CITY OF ALBUQUERQUE

Re: 7121 Washington (Harroun)
7121 Washington Ave. NE
Traffic Circulation Layout
Architect's Stamp 11-21-16 (D17-D016)

Based upon the information provided in your submittal received 11-21-16, the above referenced plan cannot be approved for Building Permit until the following comments are addressed:

A5 TRAFFIC CIRCULATION LAYOUT
1" = 20'-0"

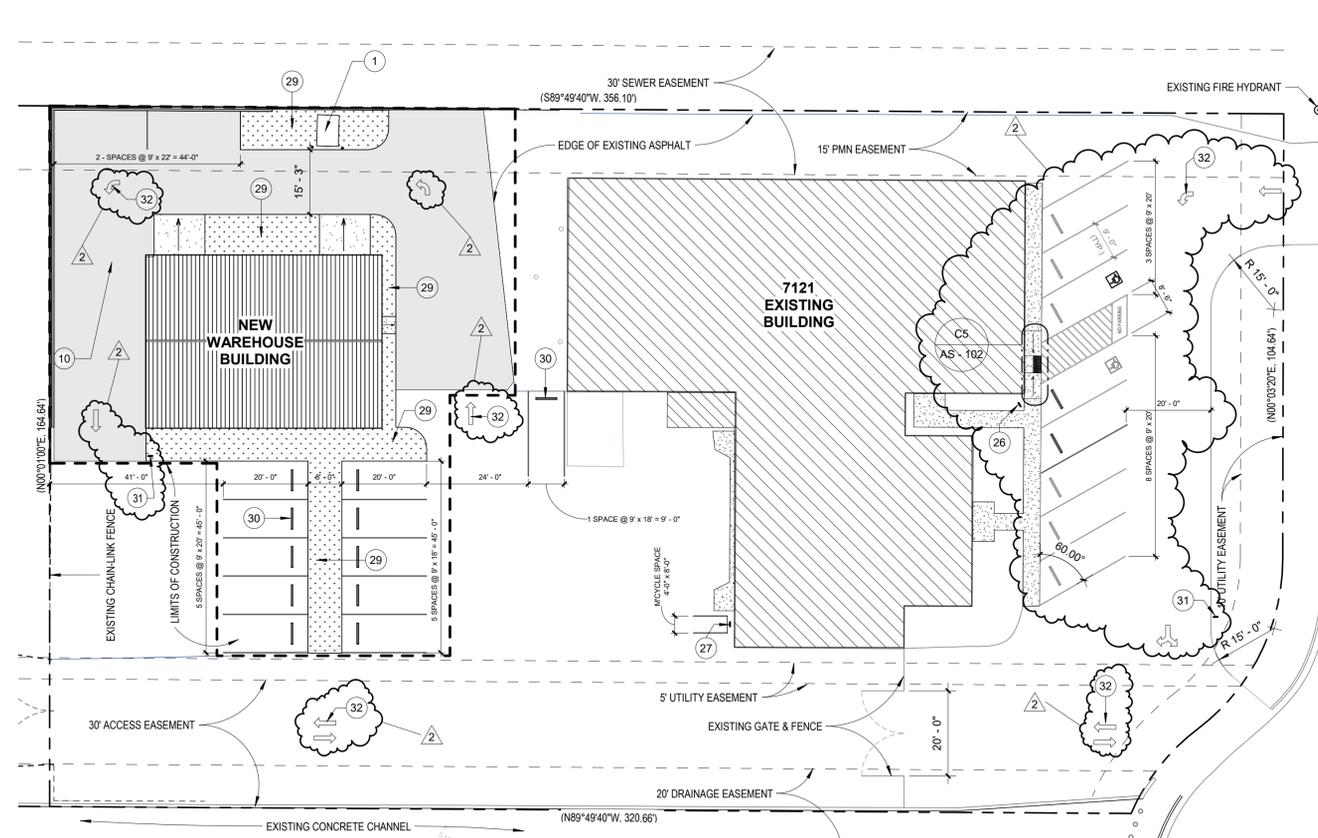
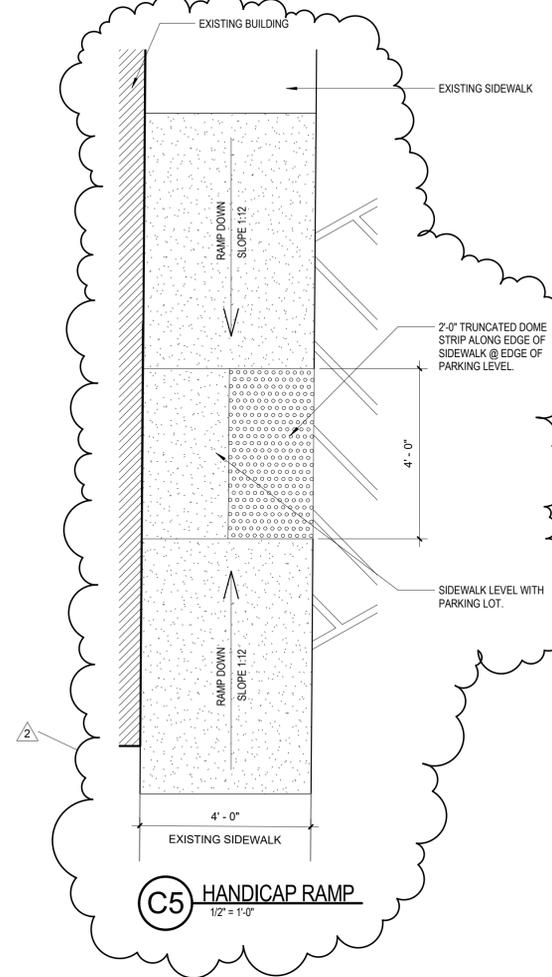
1. Please identify and dimension existing sidewalk, drive pads, and handicap access ramp and anything that influences the parking and circulation on the site.
2. Please dimension the width between the parking stall and existing fence.
3. Identify if the parking at the existing building will be restriped or is existing. The handicap ramp should be located on the sidewalk and not in the handicap access aisle.
4. All one-way vehicular paths require pavement directional markings and a posted **"Do Not Enter"** sign at the point of egress. Please show detail and location of posted signs.
5. List radii for all curves shown; for passenger vehicles, the minimum end island radius for passenger vehicles is 15 ft. Radius for delivery trucks, fire trucks, etc. is 25 ft. or larger.
6. Please contact me @ 505-924-3630 to discuss TCL before submitting.
